Consultee Comments for Planning Application 22/01212/STVAR

Application Number: 22/01212/STVAR

Proposal: Variation of Condition 7 (Landscaping Scheme) of planning permissions 18/30394/CONDET and 17/01035/REG3 - Extension and re-organisation of existing Caravan Park comprising: changes to existing touring area to accommodate 77 static caravans following demolition of existing amenity blocks and reception building; provision of 66 tent pitches, 208 touring caravan/camper pitches, 59 static caravan pitches and 19 lodge (twin unit) pitches; construction of welcome area; erection of a reception building and two amenity block buildings; external landscaped recreation/amenity spaces; and associated infrastructure and landscaping
Case Officer: Mr Matthew Sunman

Name: . Building Conservation .

Proposed 2.4m Paladin Weldmesh Galvanised Steel Vision Panels in Green with Powder Coated Posts (1:50)

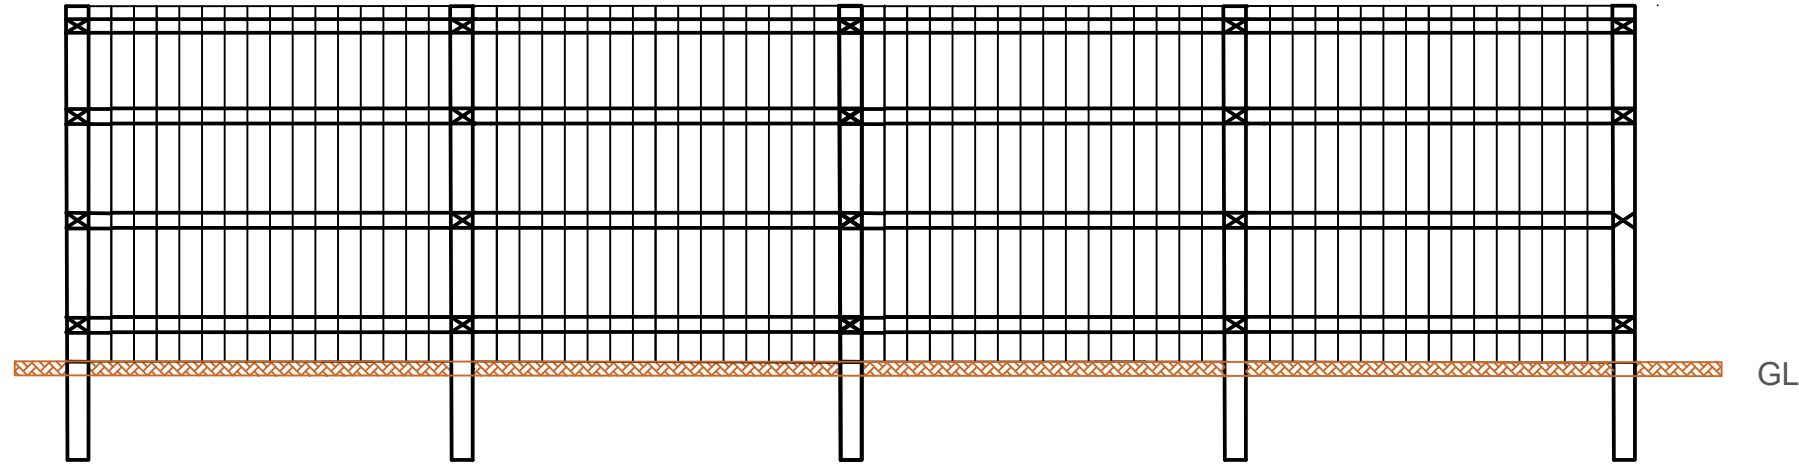
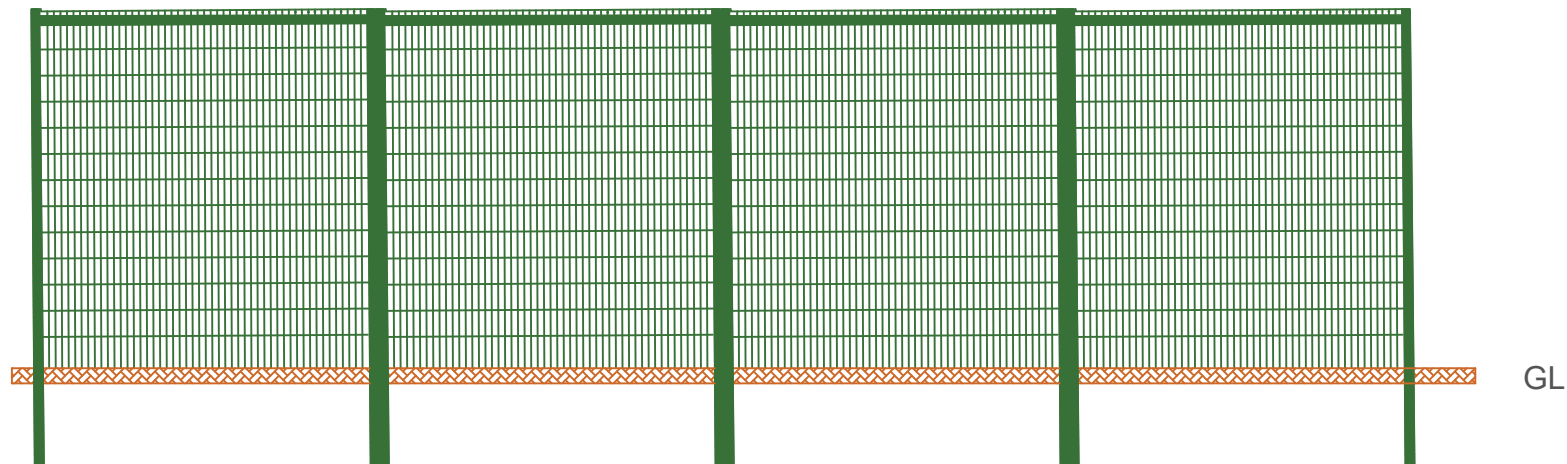
The proposal is to amend existing 2.4m in height timber close-board fencing for 2.4m in height v mesh Paladin fence. Having reviewed the submitted documents, the proposal will have no additional heritage impact on designated heritage assets, therefore there are no objections.
